**ADC Planning Consultation
Conservation/Design Officer Response**

Application Number	LU/50/17/PL
Address	70 High Street, Littlehampton
Description	Alteration to a Building of Special Character, adjacent to a listed building
Case Officer	David Easton
Date	10 May 2017

Architectural Designs Bank Chambers 29, High Street Ewell, Surrey, KT17 1SB. Telephone: 0800 331 7732	
Project: No 70 Lion St. Letchworth	
Title: Proposed new dormer window to the rear roof - Roca	
Scale: 1:100	
Date: December 2015	
Drawing No: 1512-1887

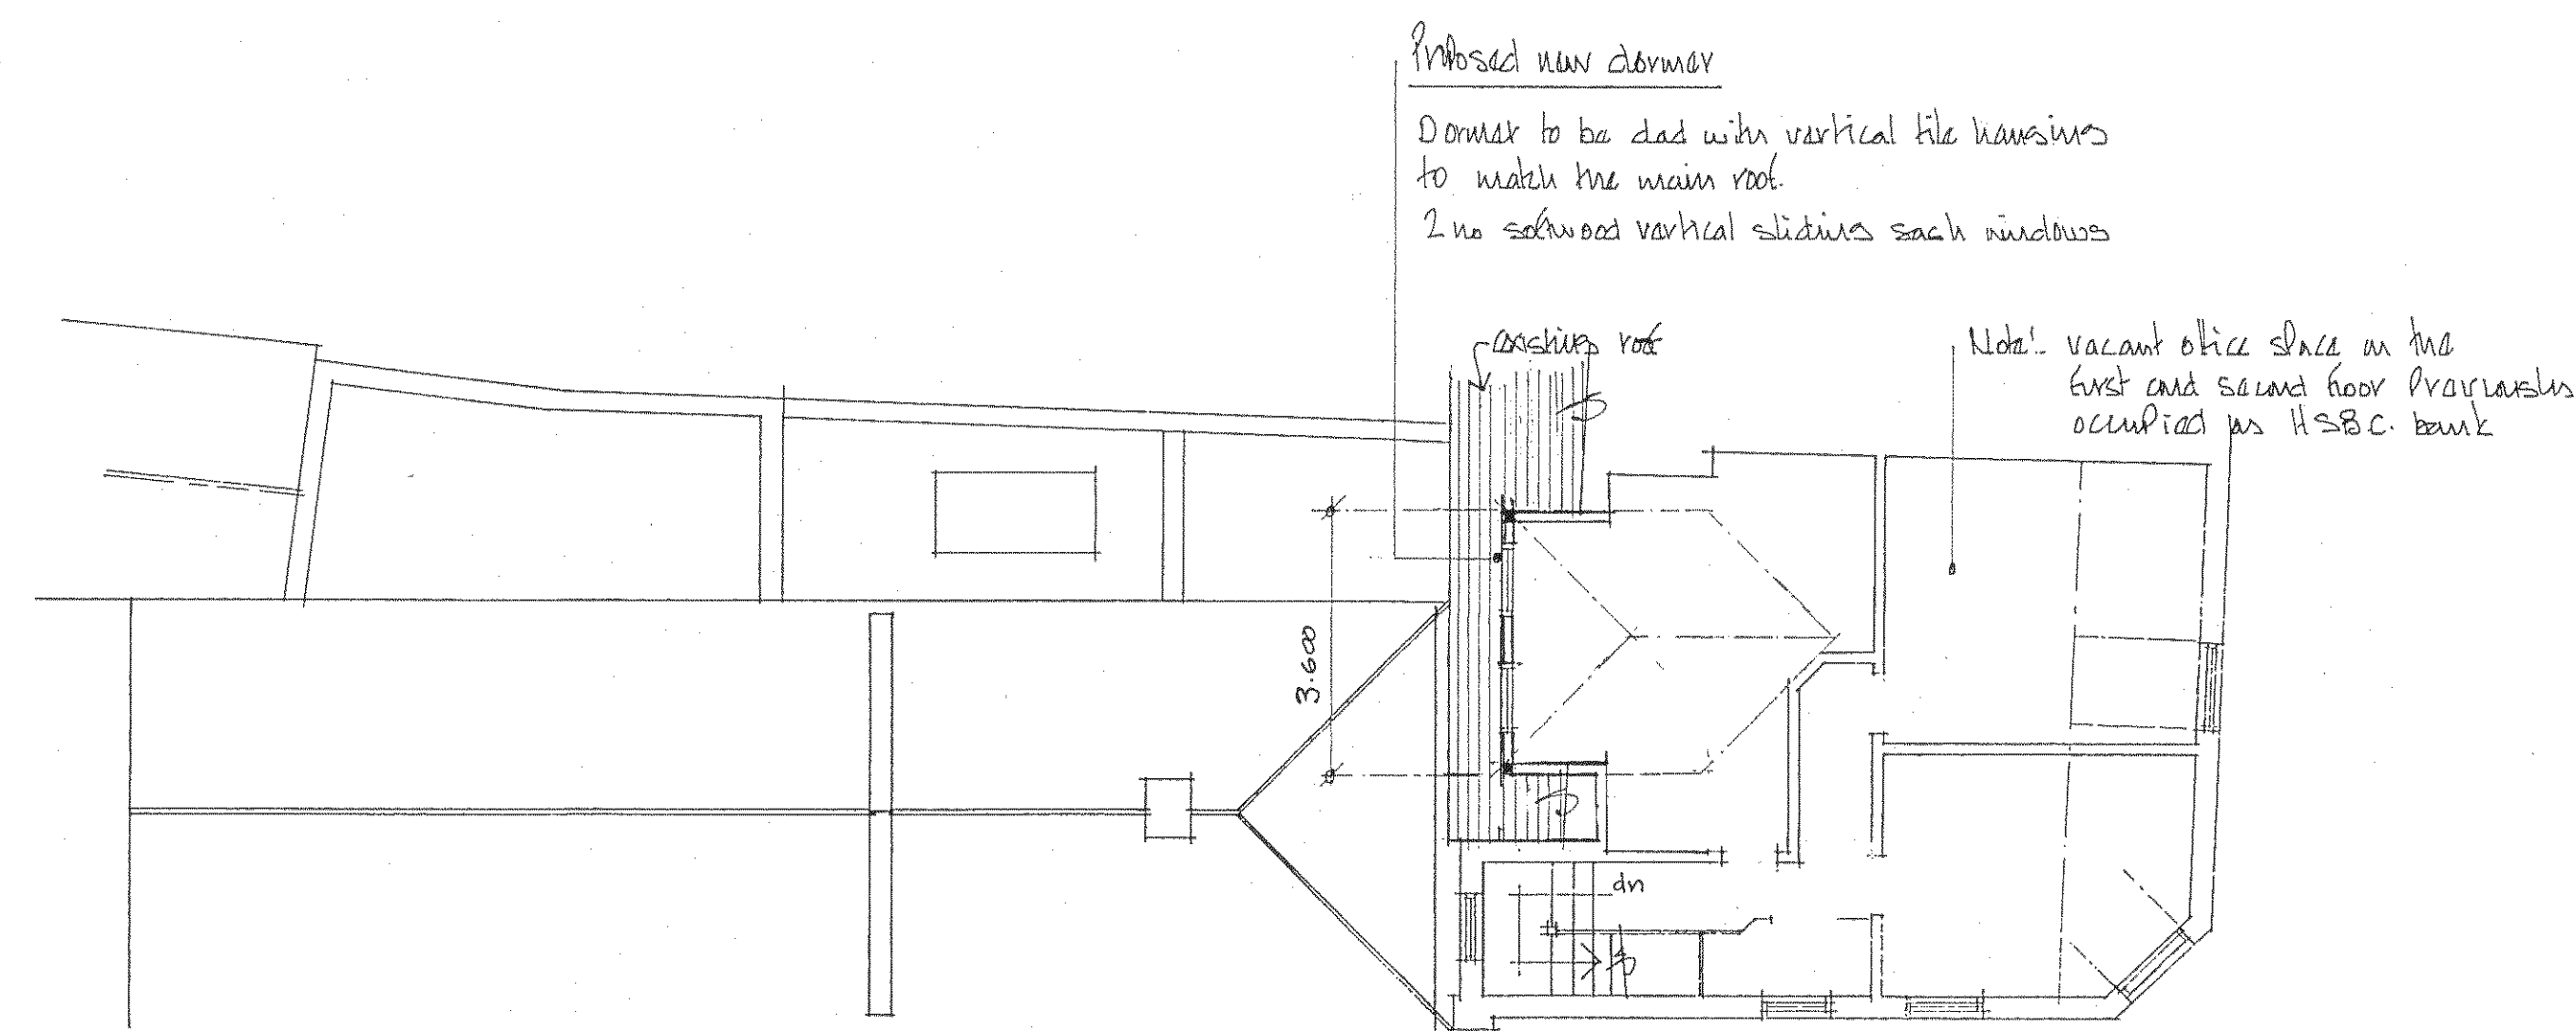
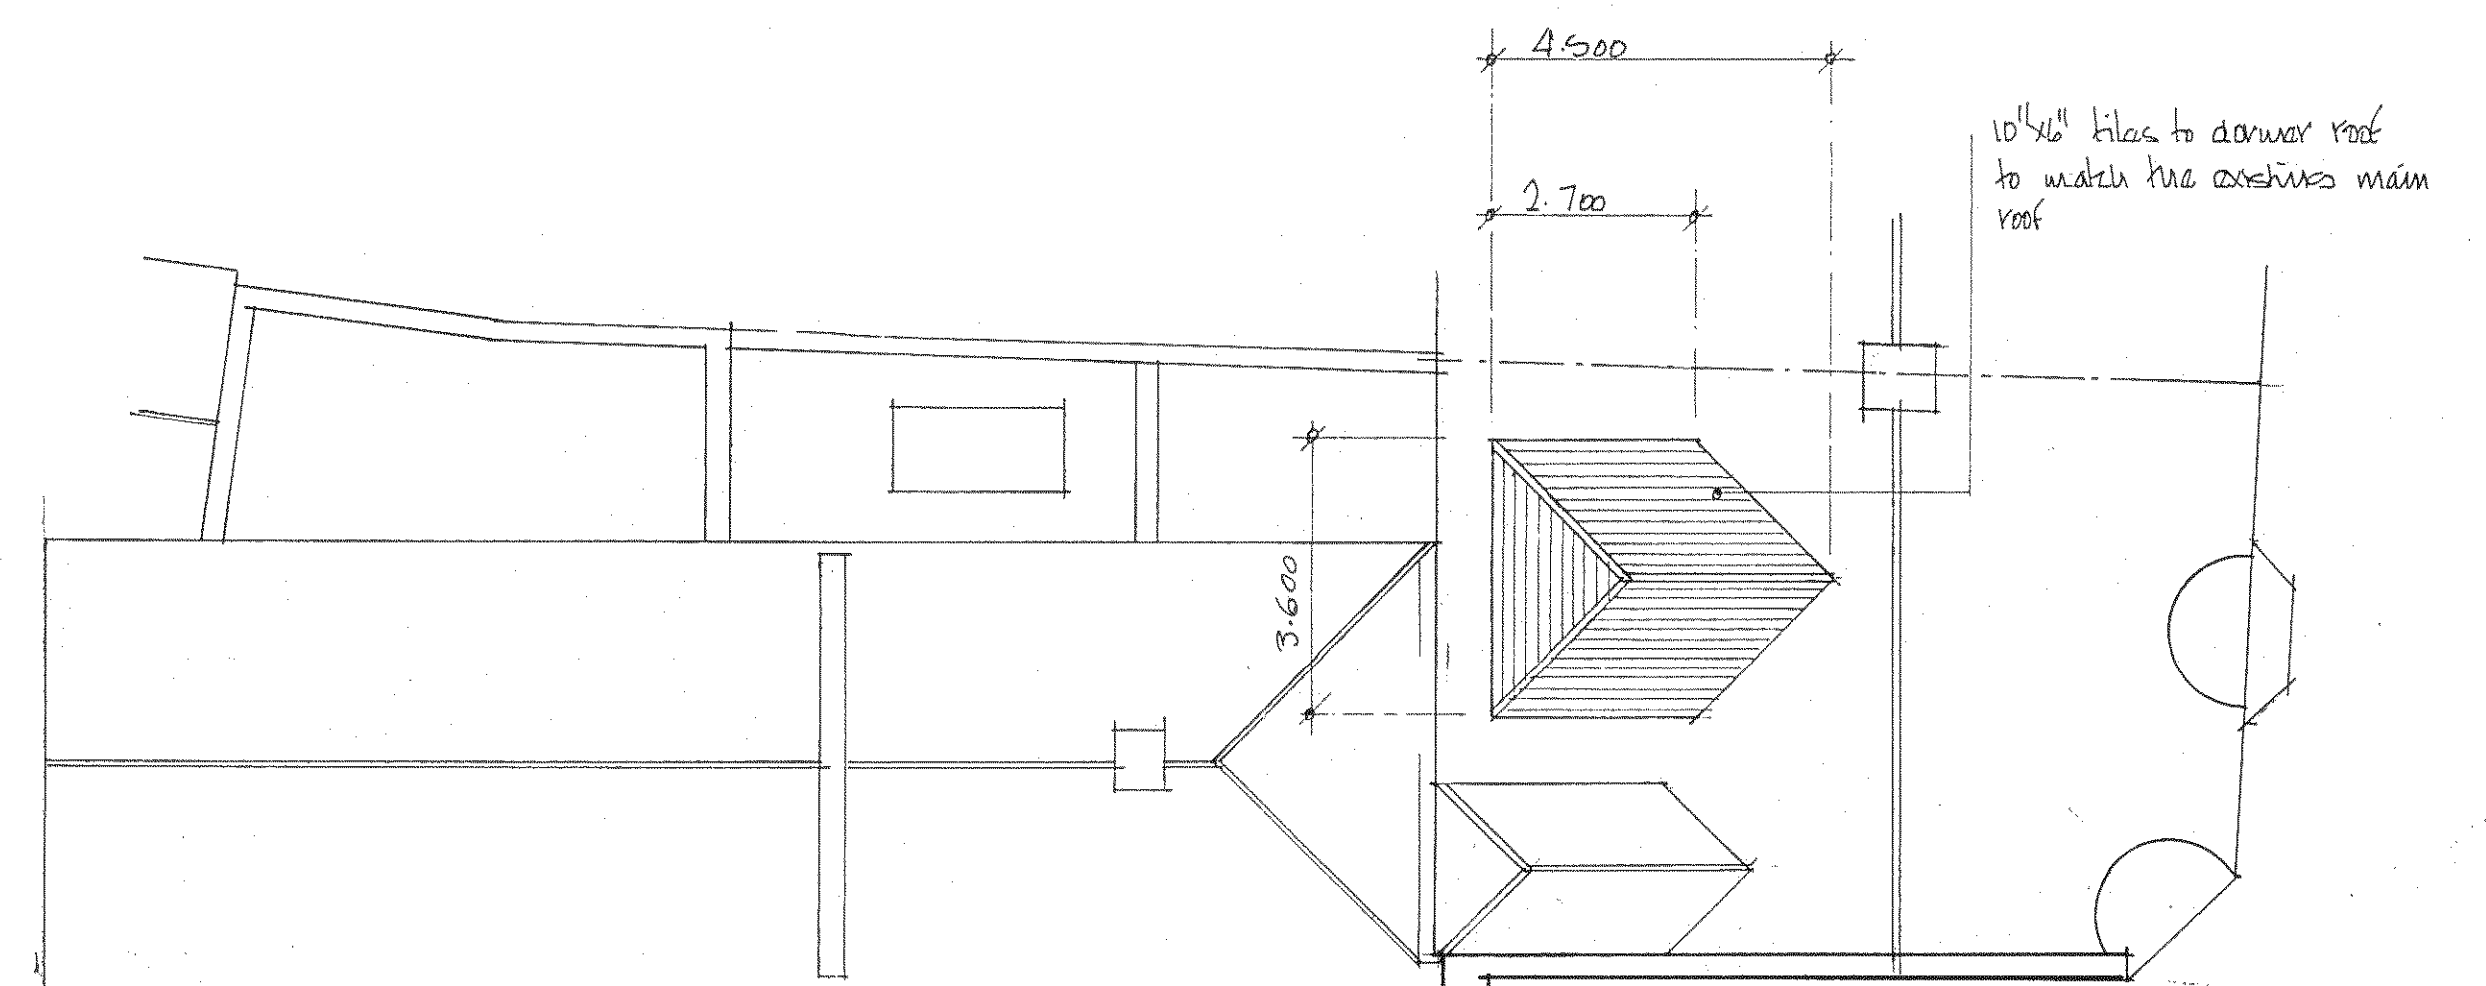
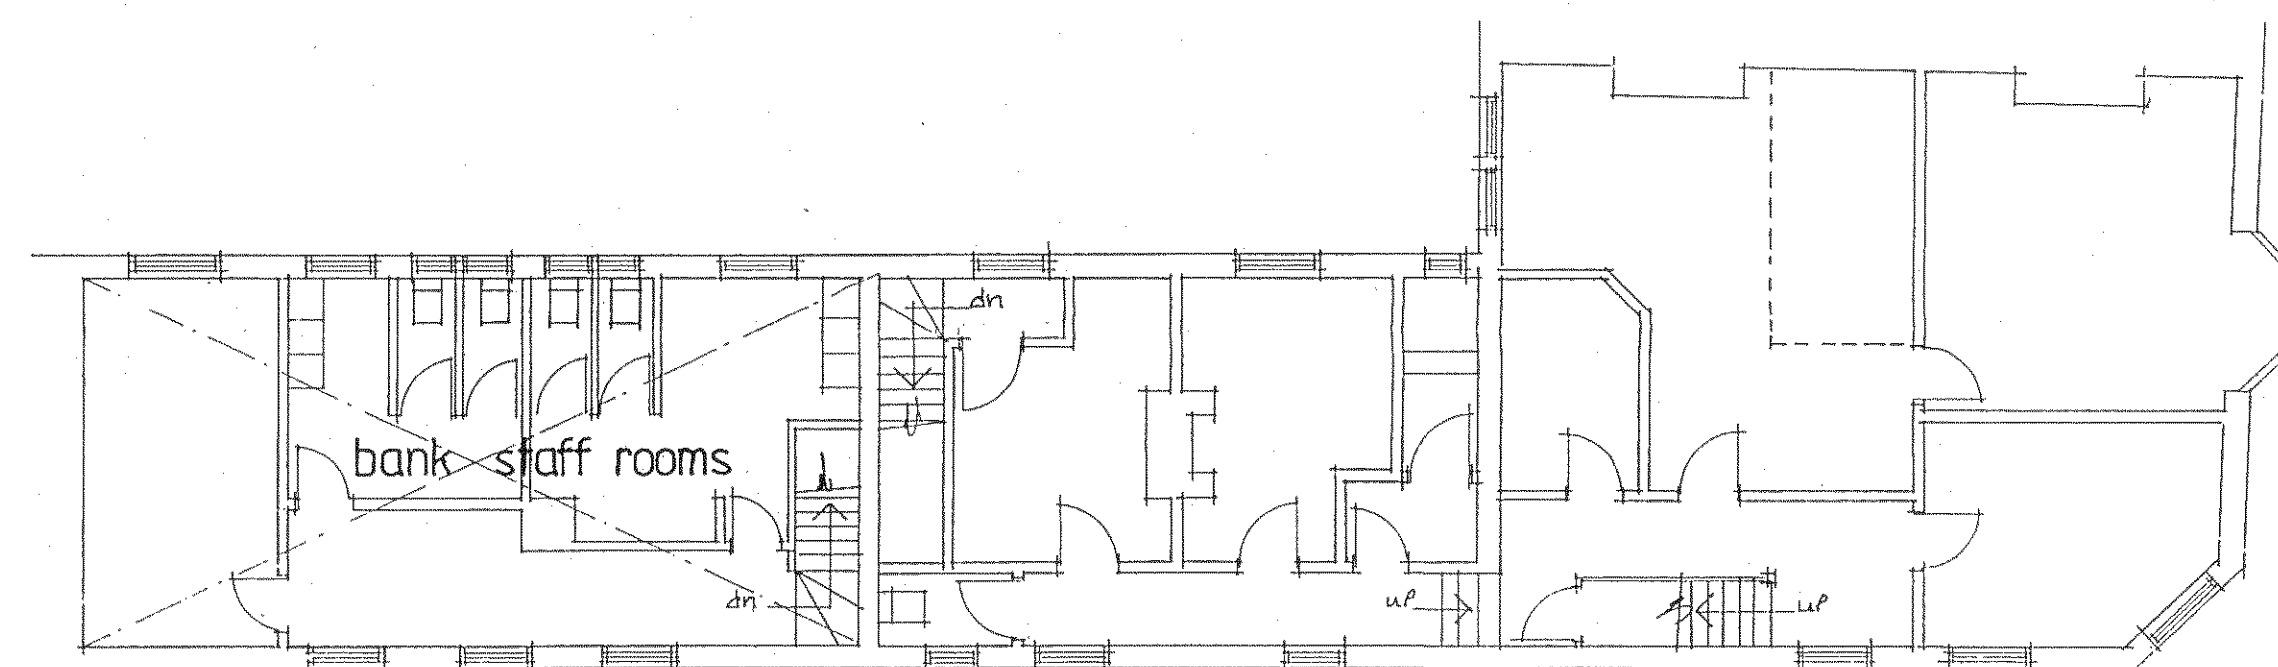
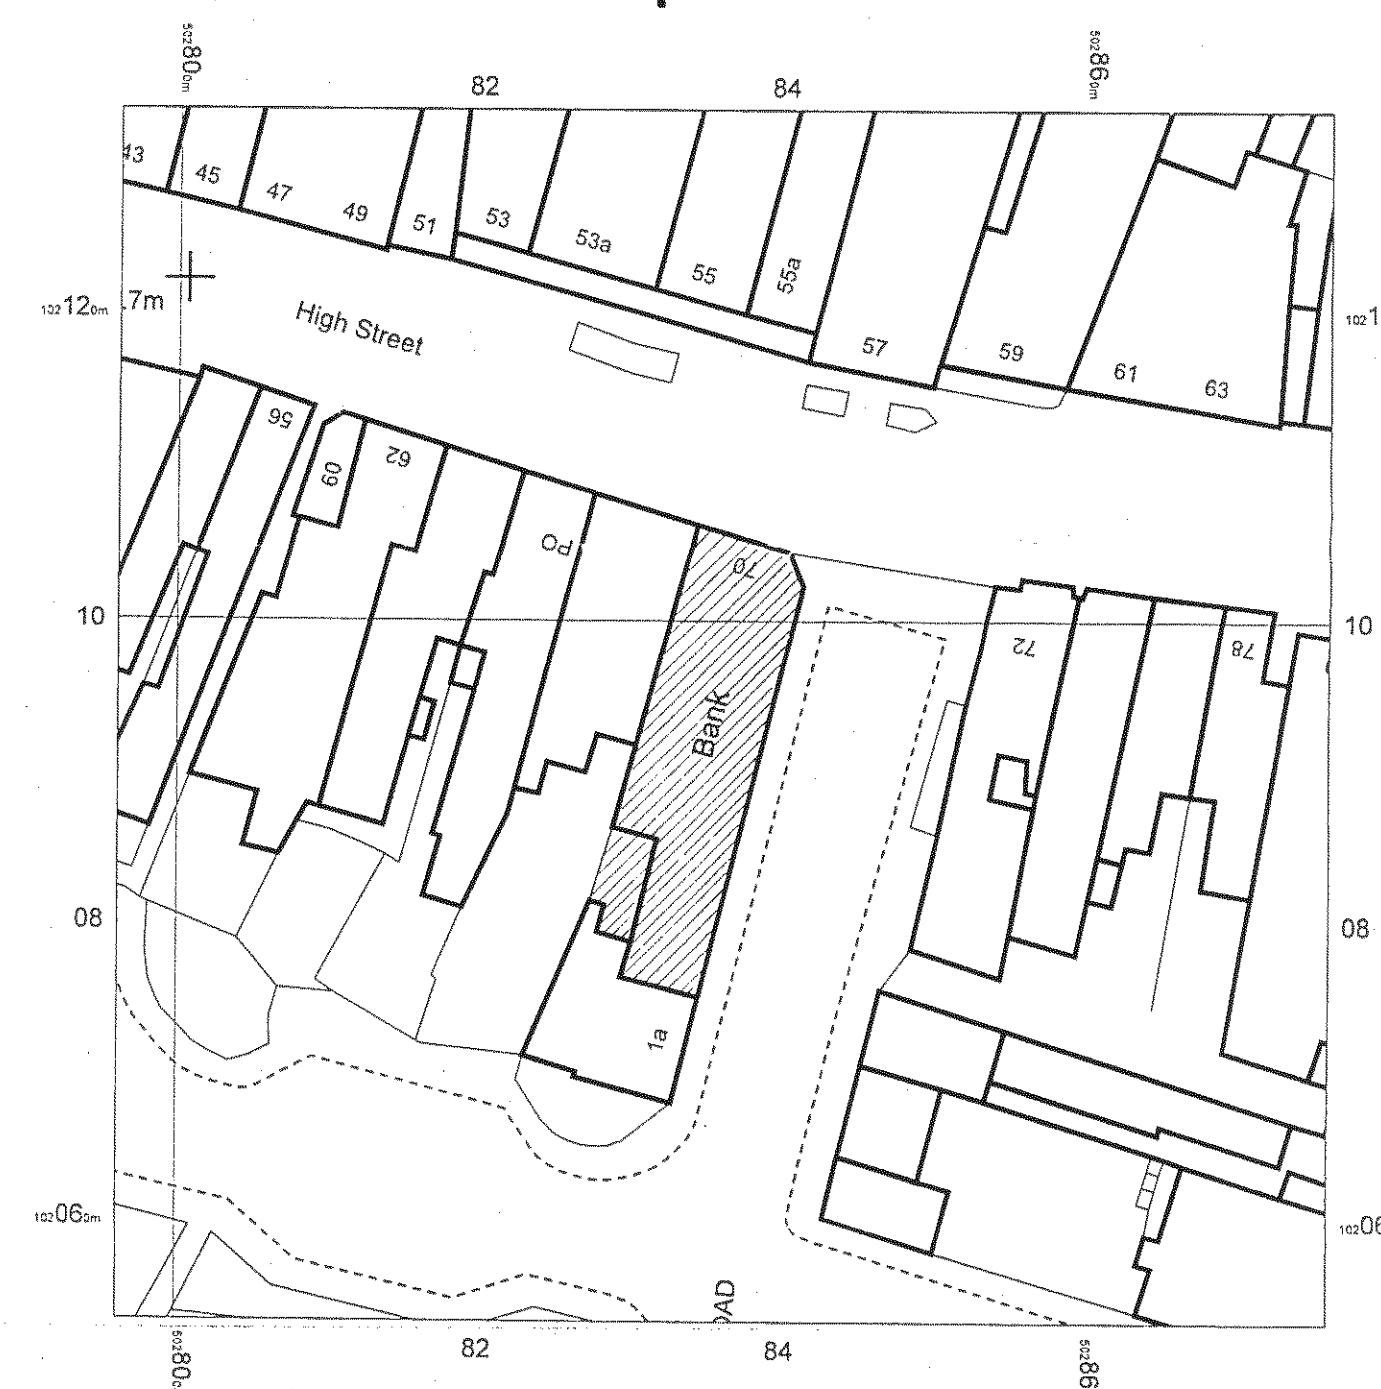
70 High Street is designated as a building of Special Character and it is located in close proximity to a Grade II listed building. The presence of the proposed dormer will cause no harm to the significance of the neighbouring listed building and there is no objection in terms of Policy HER DM1. However, the host building is locally listed and the proposed bulky dormer diminishes its aesthetic quality. While a modestly scaled dormer of traditional proportions may be possible in this location, the bulky structure now proposed has an overbearing presence which unbalances the rear elevation of the host building.
